Comment for planning application 23/01233/OUT

Application Number	23/01233/OUT
Location	OS Parcel 4347 East Of Pipal Cottage Oxford Road Kidlington
Proposal	Outline application (with all matters except access reserved for future consideration) for the demolition of existing buildings and the erection of up to 800 dwellings (Class C3); a two form entry primary school; a local centre (comprising convenience retailing (not less than 350sqm and up to 500sqm (Class E(a))), business uses (Class E(g)(i)) and/or financial and professional uses (Class E(c)) up to 500sqm, café or restaurant use (Class E(b)) up to 200sqm; community building (Class E and F2); car and cycle parking); associated play areas, allotments, public open green space and landscaping; new vehicular, pedestrian and cycle access points; internal roads, paths and communal parking infrastructure; associated works, infrastructure (including Sustainable Urban Drainage, services and utilities) and ancillary development. Works to the Oxford Road in the vicinity of the site to include, pedestrian and cycle infrastructure, drainage, bus stops, landscaping and ancillary development

DRAWN	CHECKED	APPROVED
PH	JDW	JDW
PROJECT No:	SCALE @ A1:	DATE:
ITB16565	1:500	13.01.23
DRAWING No:	ITB16565 - SK - 067	
		REV: H

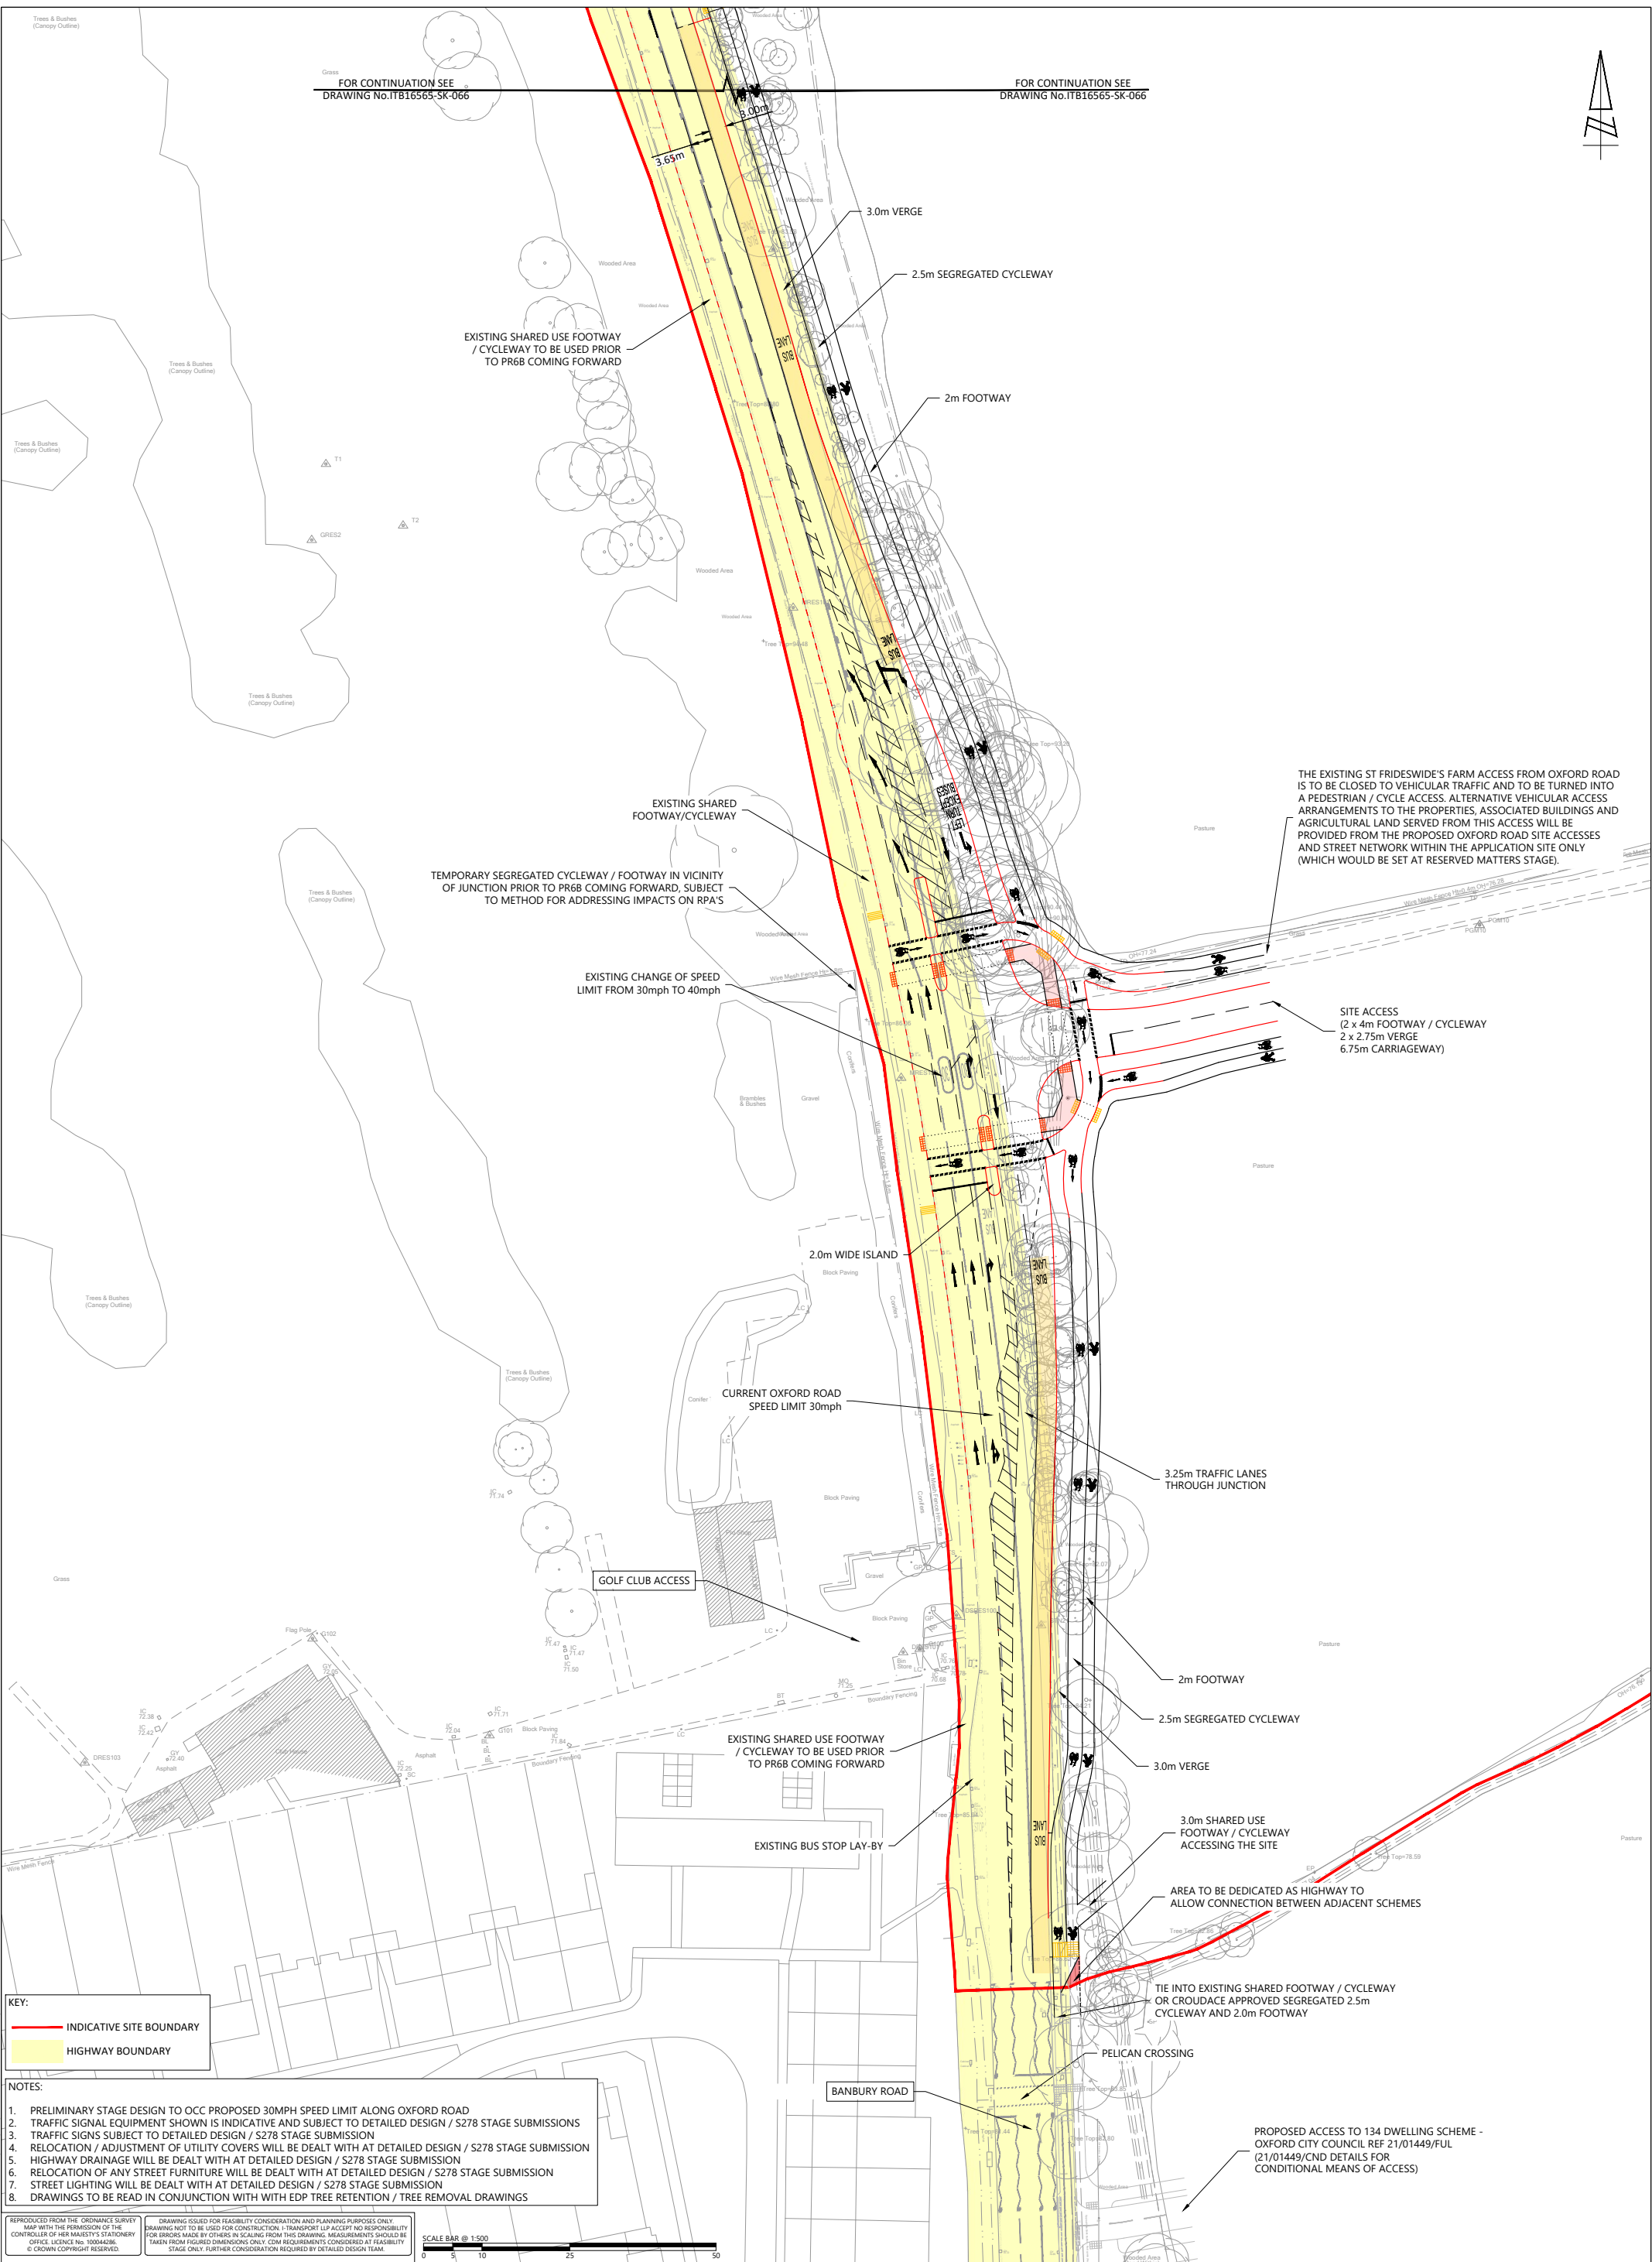
Case Officer	Linda Griffiths
Organisation Name	
Name	A. Tanovic
Address	St Frideswides Farm,Oxford Road,Gosford And Water Eaton,Oxford,OX2 8HF
Type of Comment	Comment
Type	neighbour
Comments	<p>This is in regards St Frideswide's Farmhouse.</p> <p>Recommendation 6.3 in the Archeology and Heritage Assets report (Es Appendix 11.1) states "the masterplan should seek to retain an appropriate offset to the aforementioned features (garden setting and DMV site), and the listed complex [St Frideswide's Farmhouse], in order to respect its currently isolated and enclosed setting."</p> <p>To this end, it appears a buffer zone of about 50m is setup between the Farmhouse complex the site boundary (inside which are the school playing grounds), a zone which in effect is part of the Green Infrastructure Corridor. However, a public pedestrian right-of-way and cycle path run through this corridor. This raises a couple of questions:</p> <p>1) Can it be ensured that the edge of the corridor is sufficiently planted with mature vegetation and/or fenced to ensure the privacy of the Farm? (i.e. that it is not overlooked or easily intruded upon by users of the corridor).</p> <p>2) How does the (as yet unspecified) vehicular access route to the Farm traverse the Green Infrastructure Corridor? Bear in mind that agricultural vehicles and many other large vehicles (for rubbish, heating oil, septic tank servicing, gardening, courier deliveries, etc) will be regularly crossing the corridor to access the Farmhouse and adjacent complex. Currently the farm is not on any public road or footpath. Apart from potential safety issues, this vehicular traversal across a pedestrian right-of-way and cycle path creates an immediate public access point directly into the farm complex. How can this be managed?</p>
